CITY OF ALBUQUERQUE

Site: Aloha RV Addition

Re: Drainage Ordinance (14-5-2-1) Violations for Erosion and Sediment Control and Construction Site Waste(s)

EROSION AND SEDIMENT CONTROL PLAN

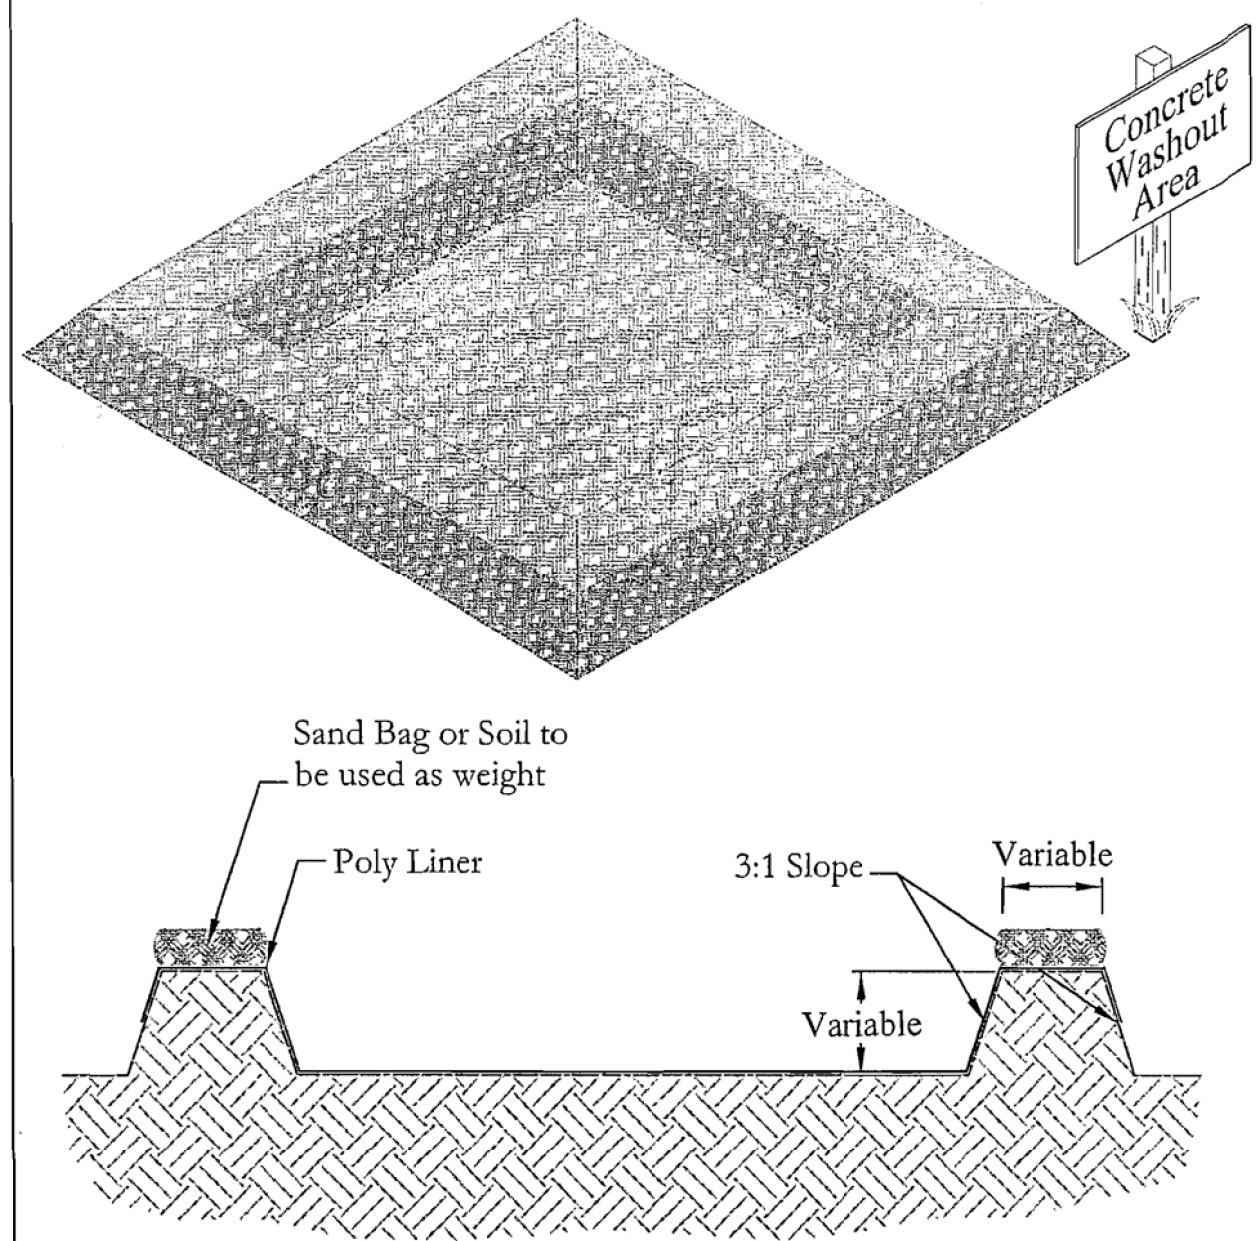
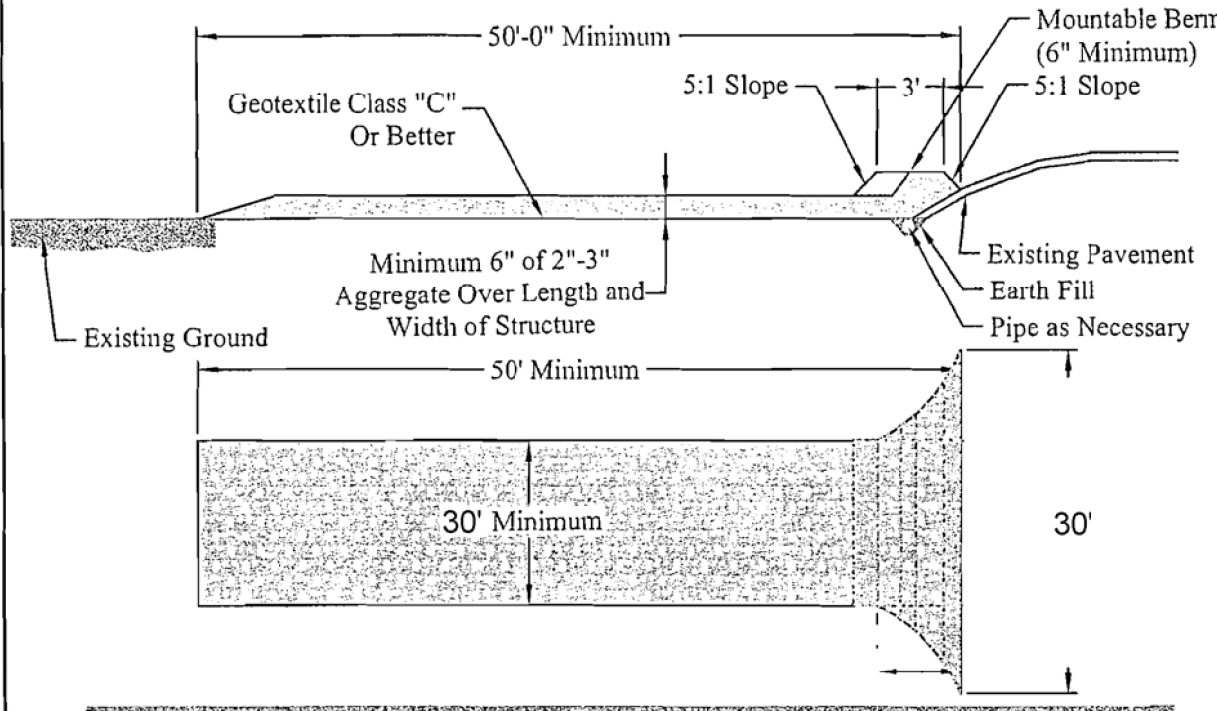
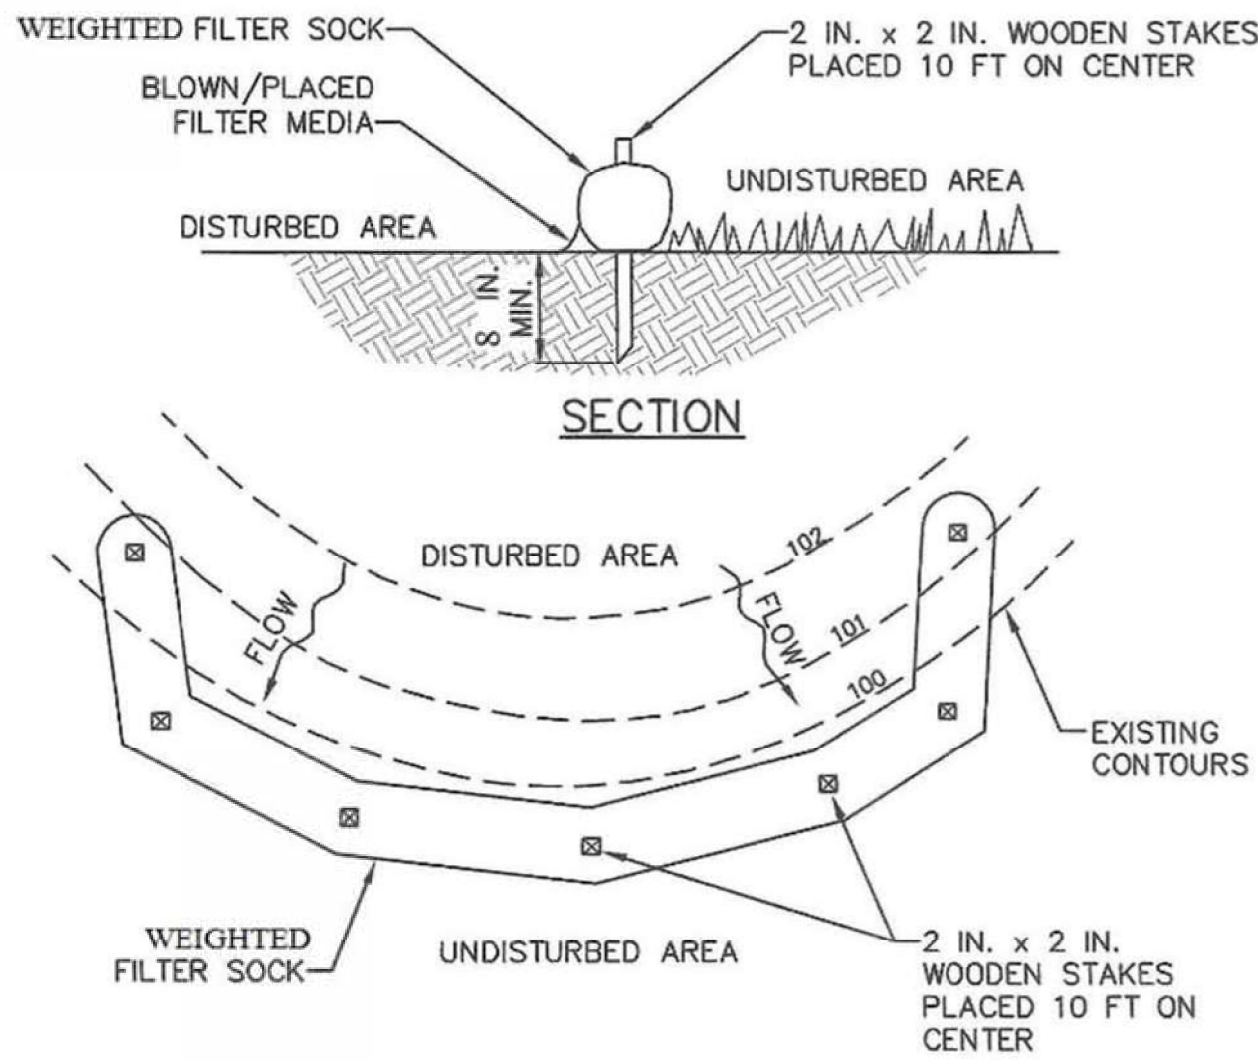
1. Self-inspection reports have not been submitted. Self-inspections and accompanying reports are required once every 14 days and within 24 hours after a precipitation event of 0.25 inch or greater.
2. The site is not posted.
3. The waste container was not covered/ no ability to cover.

1. Perform self-inspections and document conditions on an inspection report(s) and provide the report(s) to the City.

Self-inspection reports can be hand-delivered, e-mailed or kept on-site. If kept on-site, the location is to be communicated to the City and the location must be accessible to the City during regular work hours.

2. The site is to be posted per paragraph 1.5 of the NPDES CGP. The form to be completed as part of the posting requirement can be e-mailed to you if you like.
3. The waste container is to be covered when not in use and the means to cover (tarp or similar) is to be observed.
